Reference Drawings		Drawing Title	
Dwg. No.	Mfr.	Dwg. No.	Mfr.
Revision		Revision	
No.	Date	Dwn.	Appd.
7			
6			
5			
4			
3			
2			
1			
<p>FOX RUN SUBSTATION</p> <p>ELEVATION VIEWS</p> <p>TRI-STATE GENERATION & TRANSMISSION ASSOCIATION, INCORPORATED</p> <p>1100 W. 116th Ave. P.O. Box 33695 Denver, Colorado 80233 303-452-6111</p> <p>UPDATED BY: KENUTL 5/17/2022 4:56 PM Contract: .</p> <p>PATH: T:\Projects\Fox Run Substation\EL_Paso County\Dea\21036C_Elevations.dwg</p>			
Dwn: TMC	Date: 04/27/22		
Appd: .	Date: .		
ELEVATIONS

Elevation Plans_V1.pdf Markup Summary

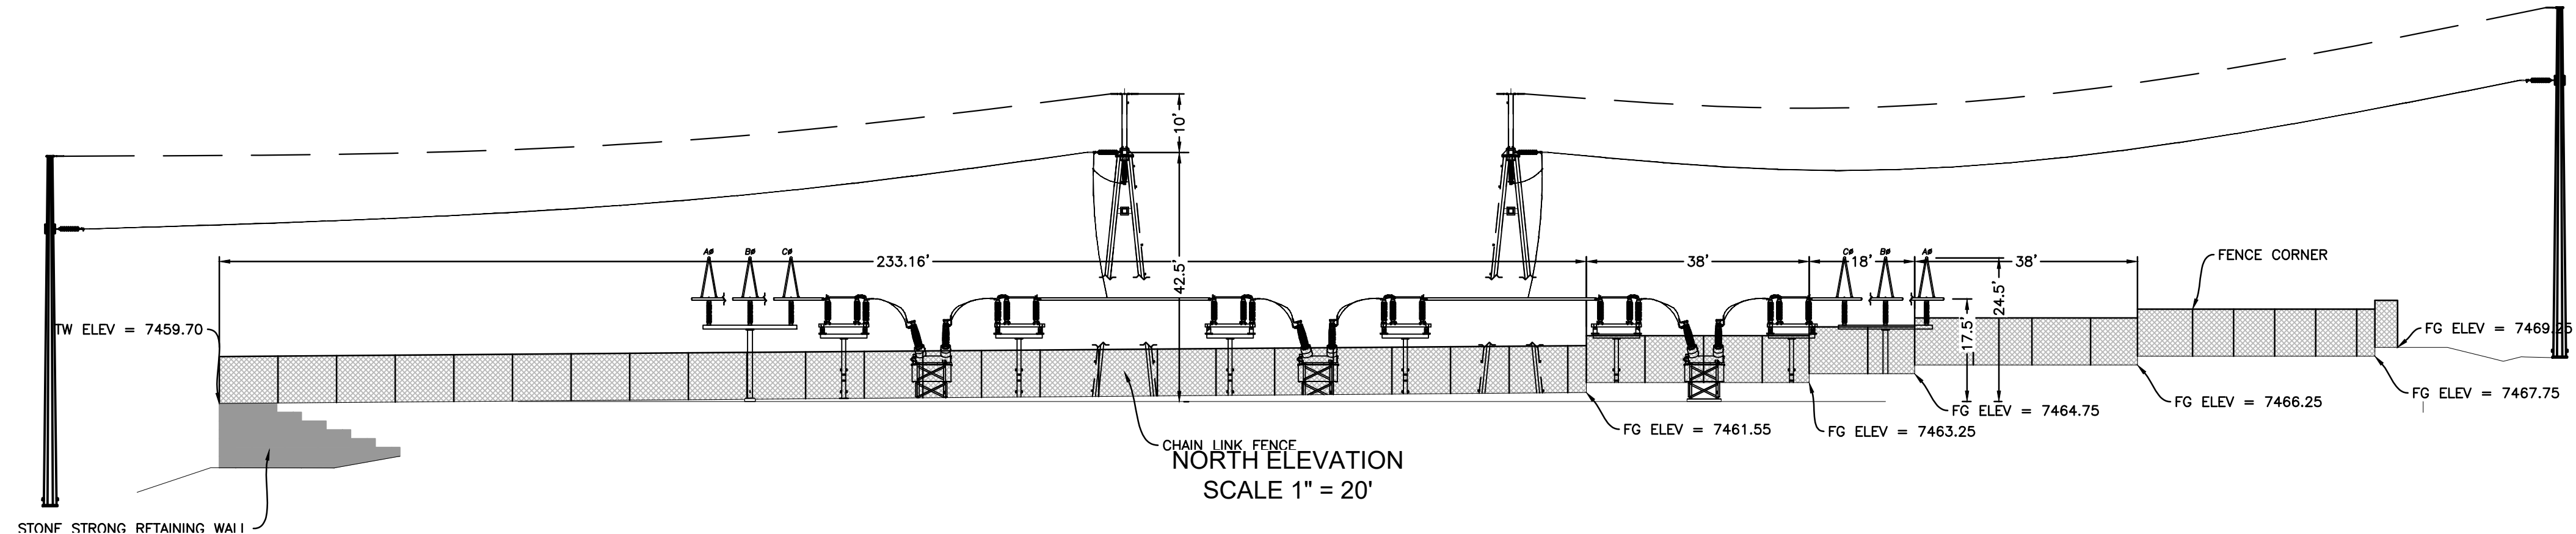
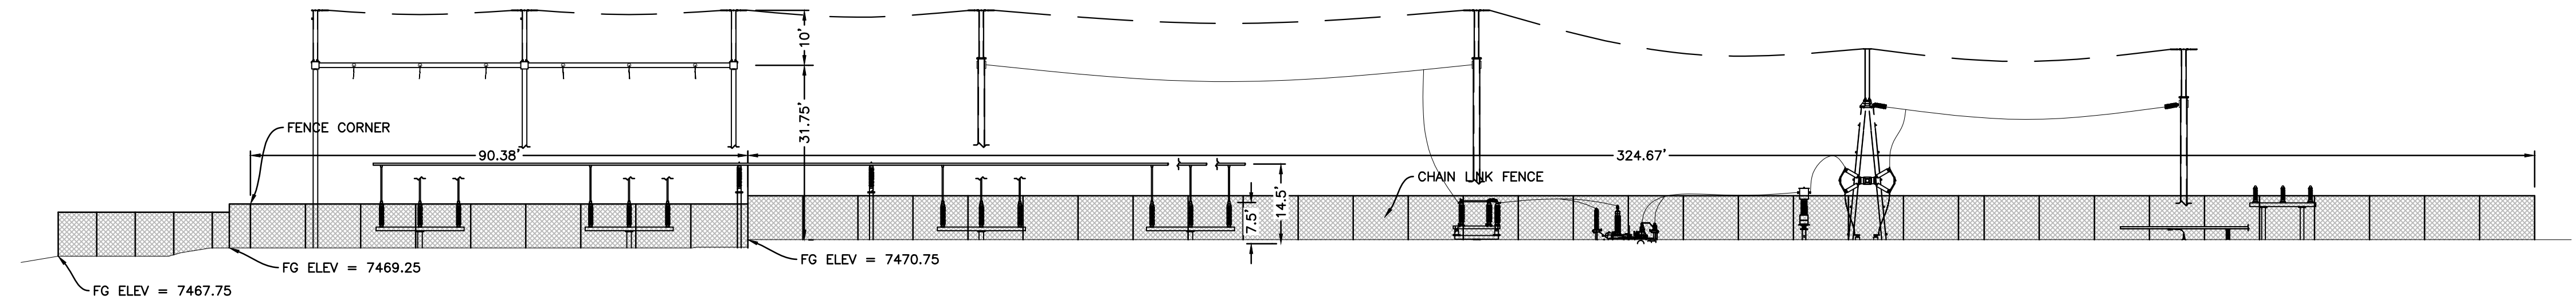
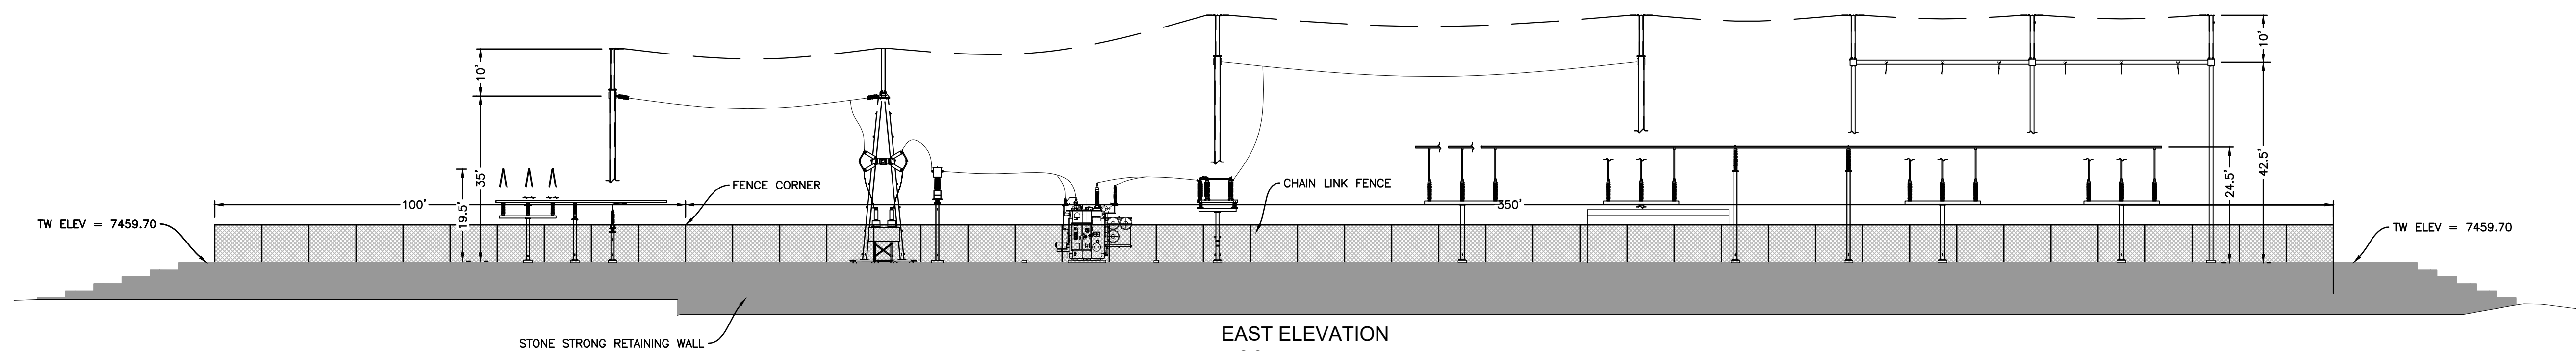
Show retaining walls on site development plan
